**Mattamy Homes Richmond Official Plan Application
Response to City of Ottawa June 8, 2009 Technical Circulation & Additional Comments
February 22, 2010**

CONSTRAINTS PLAN

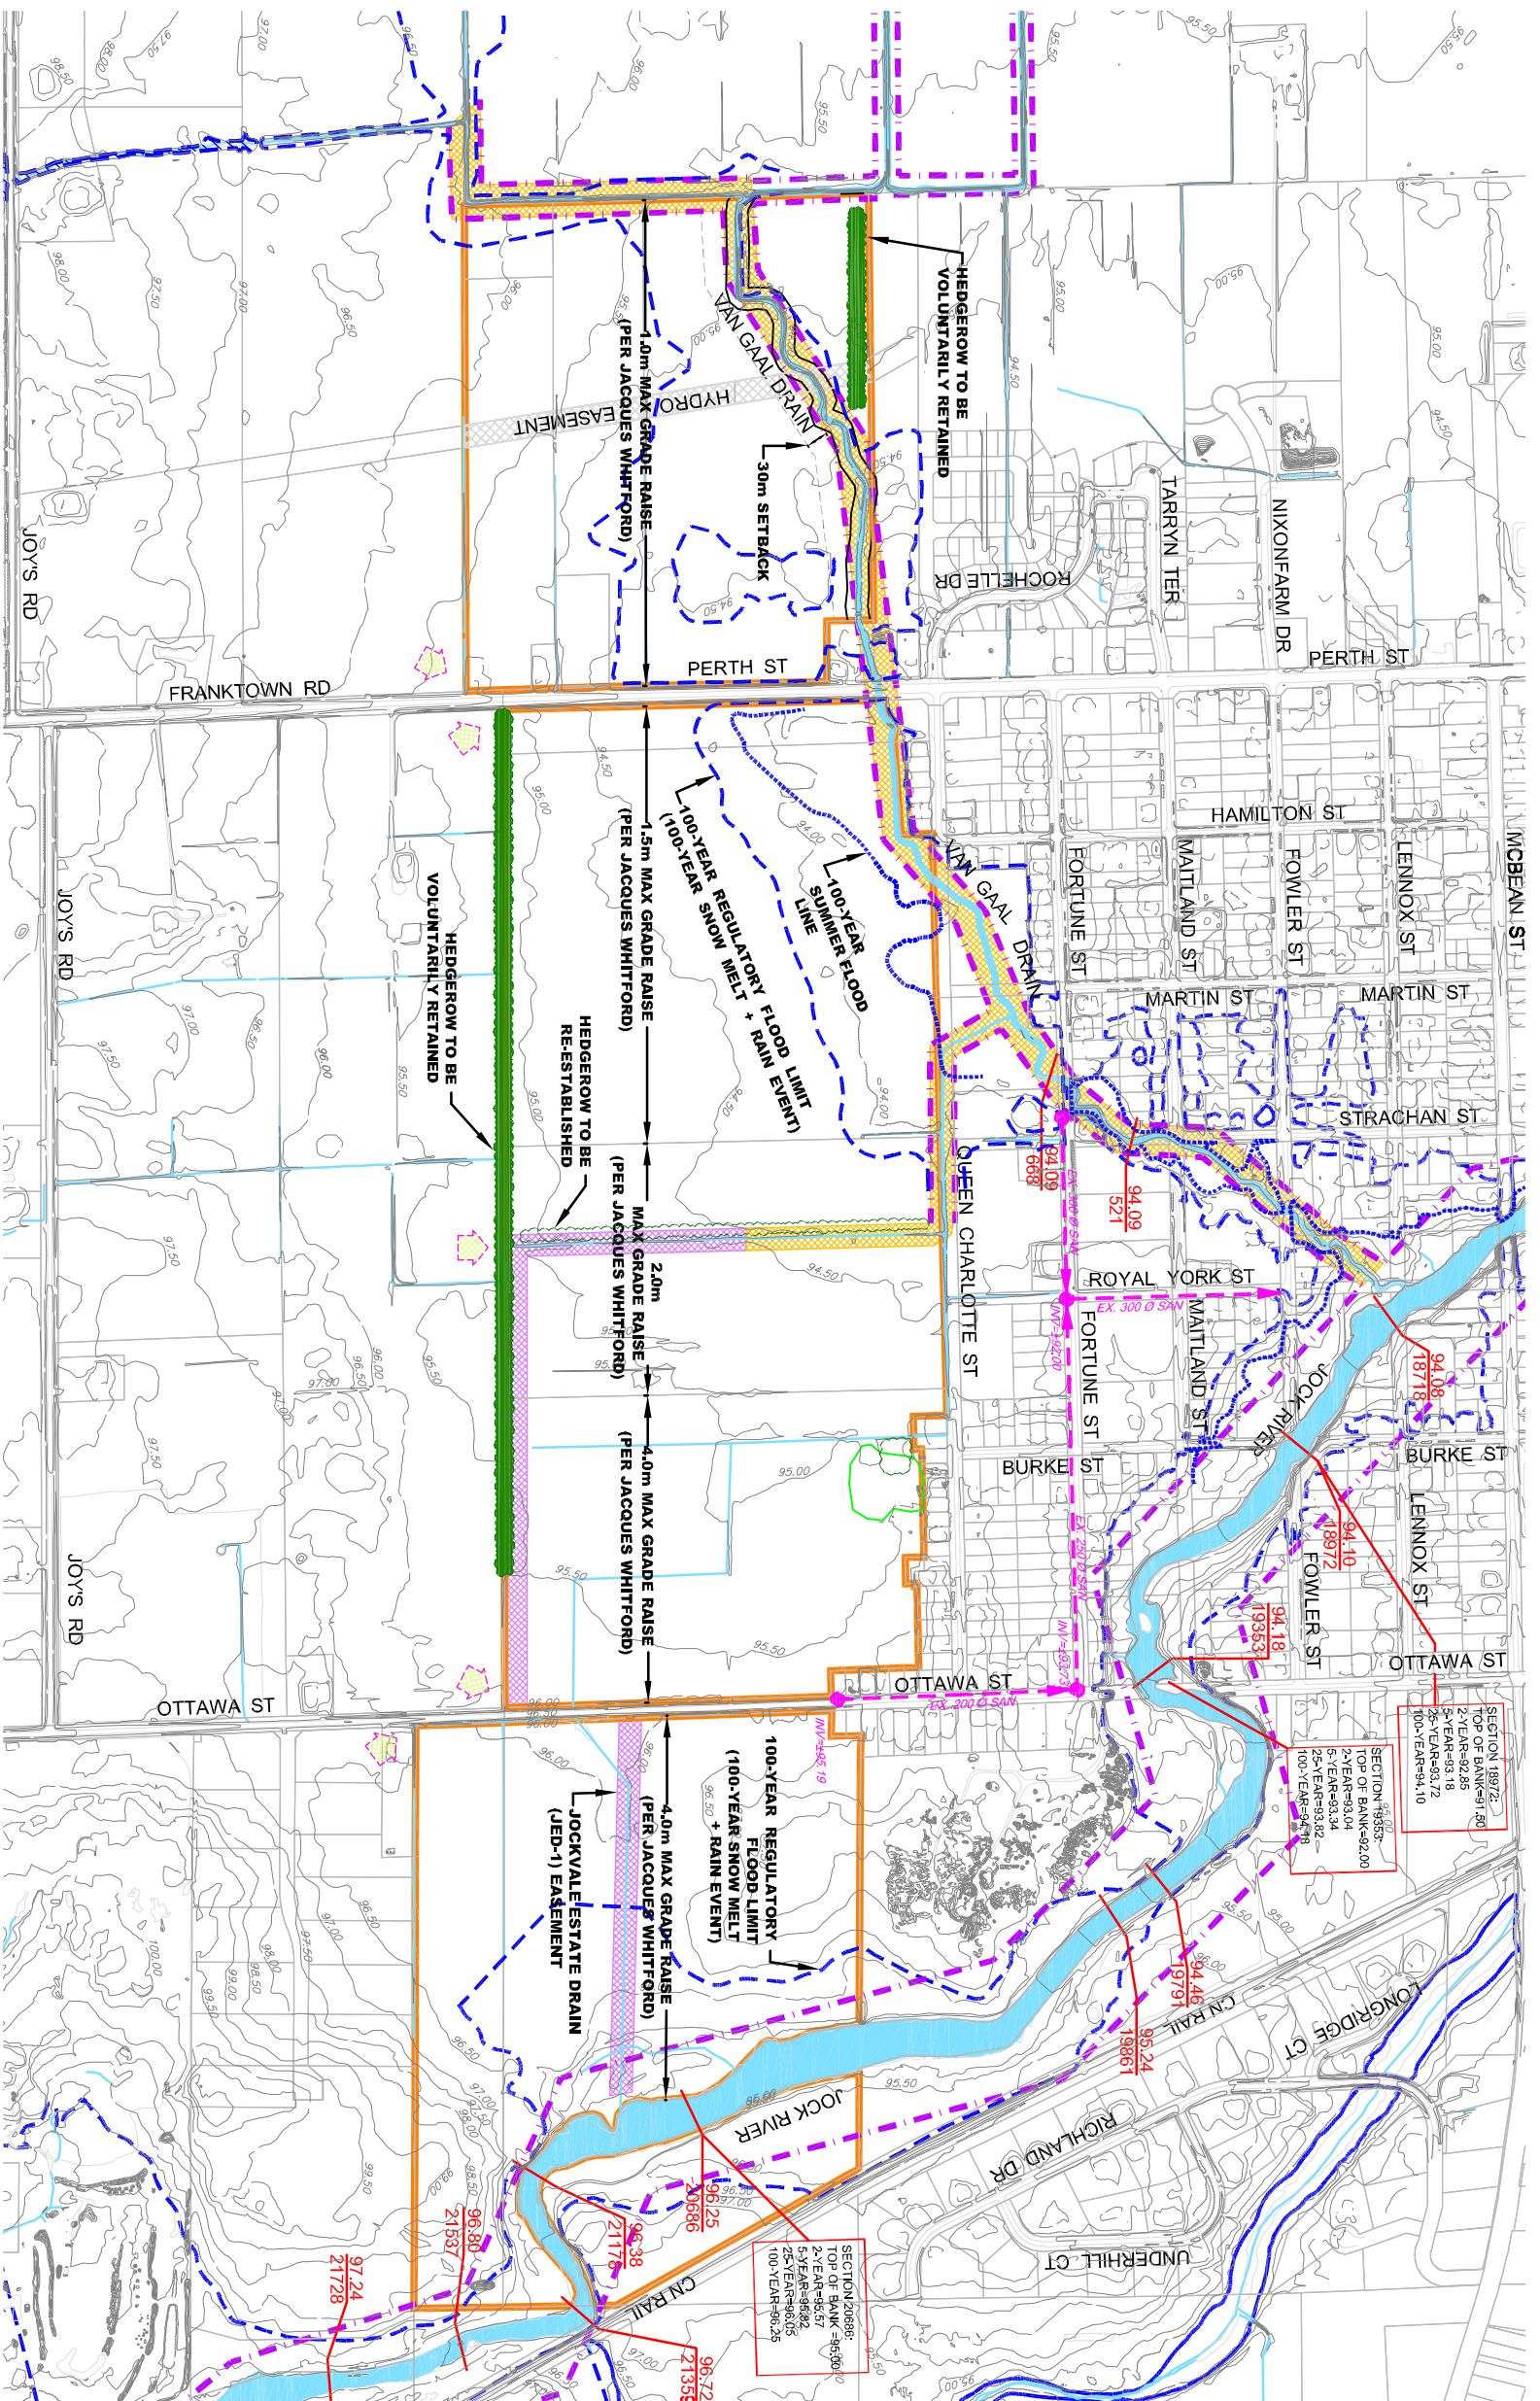
4.	The legend on Figure 23 currently refers to a 30m setback from stream centre, rather than the agreed upon 30m from normal high water mark. Natural Systems would like the stream fabric, 30m from normal high water mark, meander belt width and regulatory floodplain shown together on Figure 23. Please remove the 30m buffer from stream centre, and also show where suggesting to pipe watercourses.	City - Natural Systems Unit, July 2, 2009 Letter	July 10, 2009	<p>Stream Fabric - Figure 22 (old Figure 23) has been revised to read – <i>30m buffer from normal high water</i></p> <p>Figure 25 is the overall legislated constraint area based on the greatest aquatic, floodplain and terrestrial constraint.</p> <p>The setback table identifies the greatest constraint and setback distance.</p> <p>None of the watercourses will be piped. JED-1 will be filled in within the development area south of Ottawa Street. Please refer to revised Figure 36.</p> <p>City & RVCA September 23, 2009 Meeting: <i>Comment addressed</i></p>	<p>See Figure 22 and 25</p> <p>See Figure 36 – <i>SWM Option 3 and resulting Fish Habitats</i> for ultimate watercourse classification and status under post development conditions</p>

24.	All vegetation shown on Figure 22, should be retained and shown on Figure 25, combined environmental constraints. Figure 25 should show the existing regulatory flood plain, vegetation adjacent to the significant woodland and the woodlots and hedgerows to be retained. All drains should be marked, and drains proposed for closure should be highlighted.	City - Natural Systems Unit, July 2, 2009 Letter	July 10, 2009	<p>New Figures (27, revised 25, see comment above) showing constraint lands recommended from natural environment assessment based on regulatory framework; and, those features being proposed for retention by Mattamy Homes although only local features of interest.</p> <p>Relevant figures will be revised to include both names and identification numbers of all drains.</p> <p>City & RVCA September 23, 2009 Meeting: <i>Response satisfactory</i></p>	Please refer to Figure 31 of the revised 2010 report
